**RE: Draft Review Comment Responses / 12057 Highway 24 Multifamily Rezone
El Paso County, Colorado**

The purpose of this letter is to provide detailed responses to the CDOT Staff referral review comments (1st Review) dated March 3, 2026. We have revised the Traffic Impact Study per County and CDOT Staff comments where applicable and anticipate making further revisions upon agreement of proposed access onto U.S. Highway 24. We remain available to discuss further if needed.

**Figure 6**  
**TOTAL TRAFFIC - YEAR 2027**  
 Volumes & Intersection Geometry  
 AM / PM Peak Traffic Hour  
 (ADT) : Average Daily Traffic

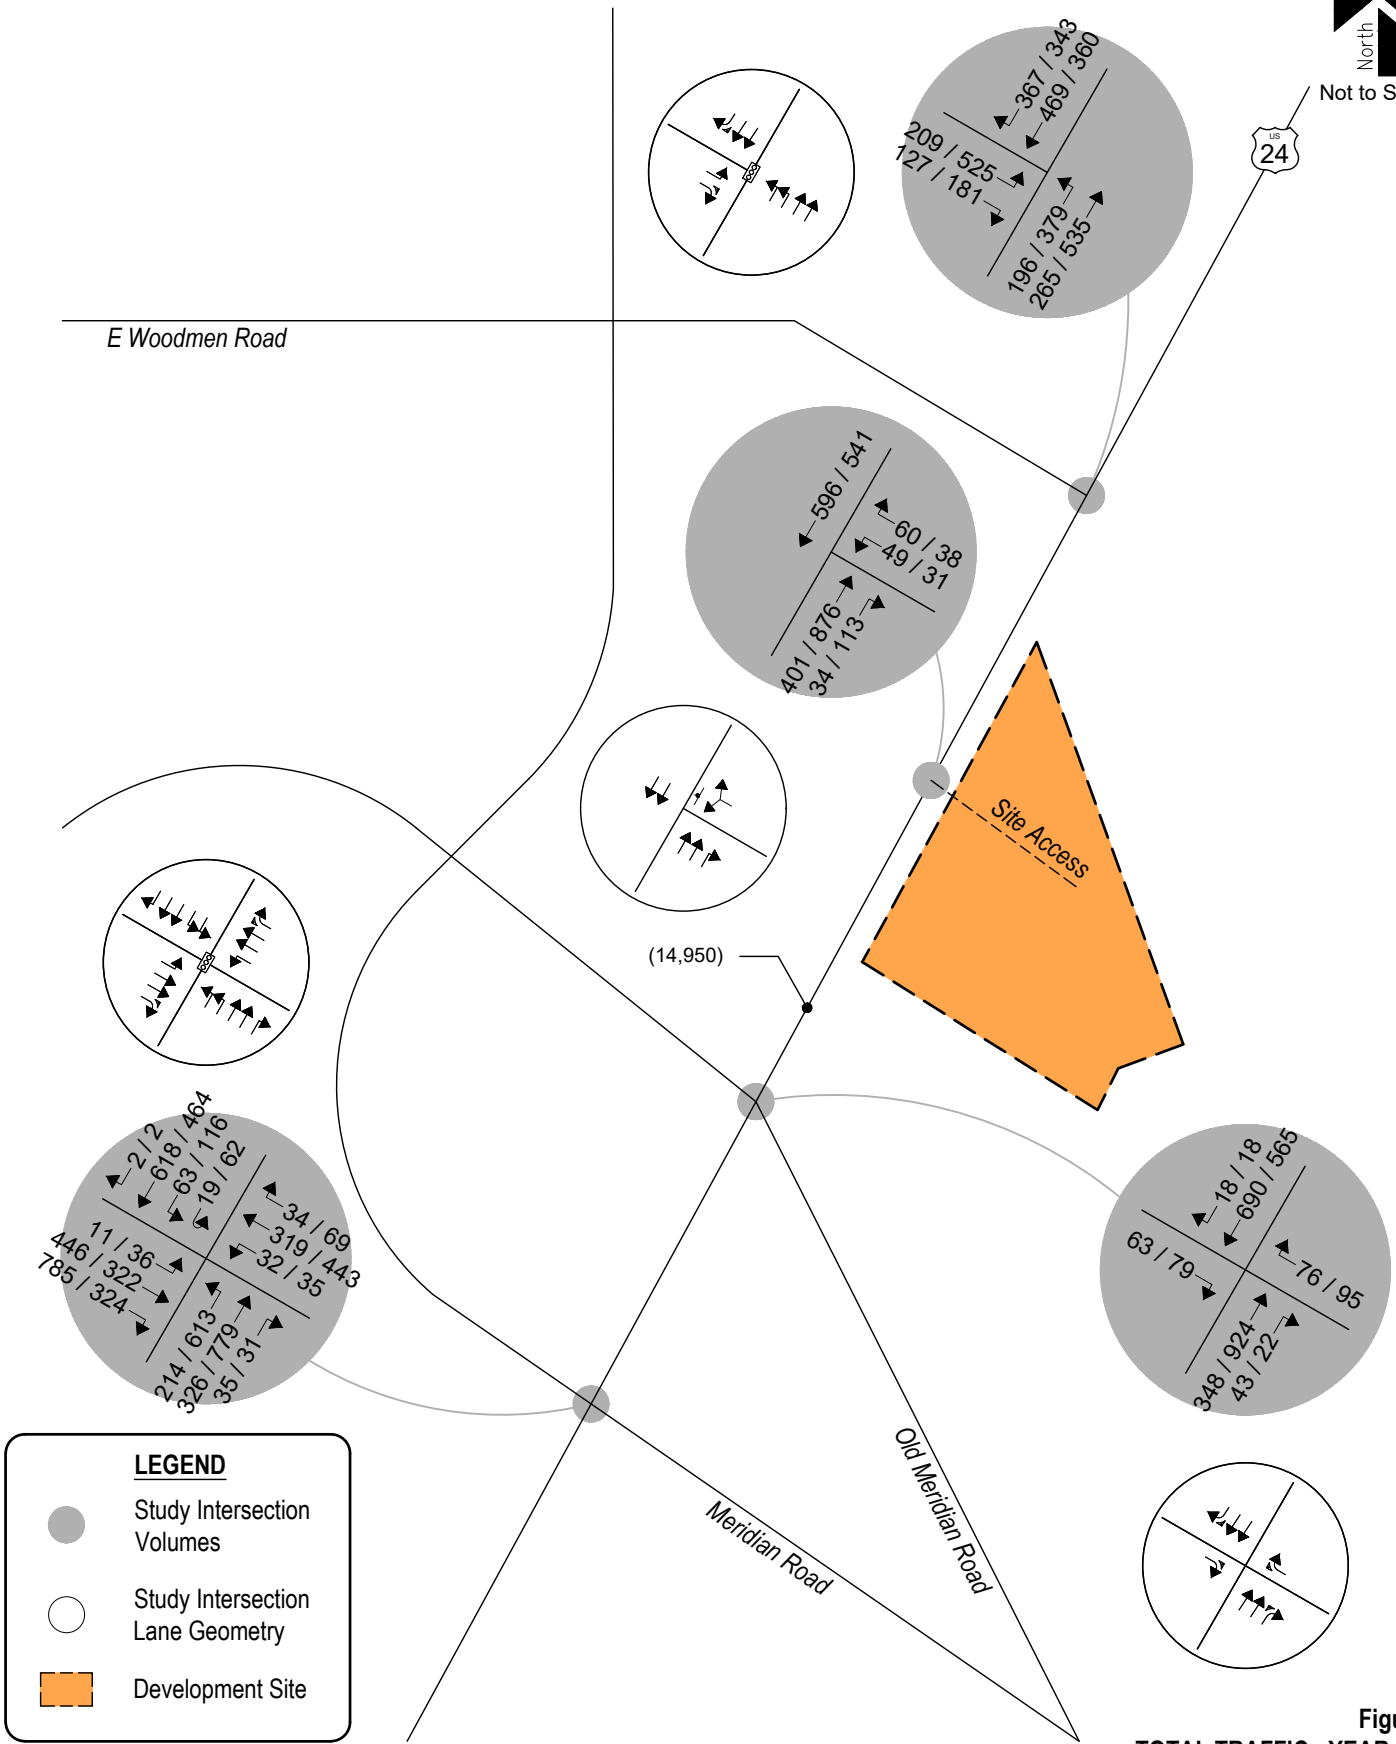
CDOT Traffic Comment 1: CDOT Project #25094 is reconstructing US-24G to include an additional thru lane in each direction, auxiliary turn lanes at the intersections, and a center raised median. The proposed full movement access onto US-24G will be constructed as a right in-out as a part of the CDOT project.

CDOT Traffic Comment 2: Revise the Traffic Impact Study to reflect changes in driveway movements and resubmit for review.

CDOT Traffic Comment 3: The applicant will be required to construct auxiliary lanes on US-24G as part of the CDOT Access Permit requirements.

Comment Response: In coordination with CDOT and Vertex, this access is being proposed as a three-quarter access with left turns out of the site. It is also noted that upon future development, and when possible this access is expected to provide full-movement access via other means and this access may be restricted to right-in/right-out.

Comment Response: Revisions made with consideration that this access provides a three-quarter movement with left turns out of the site.

Comment Response: Noted. The request to view the US-24G construction plans to understand roadway cross-section and details of right-in/out (RIRO) access construction is reiterated and needed to confirm the extent of auxiliary lane needs.
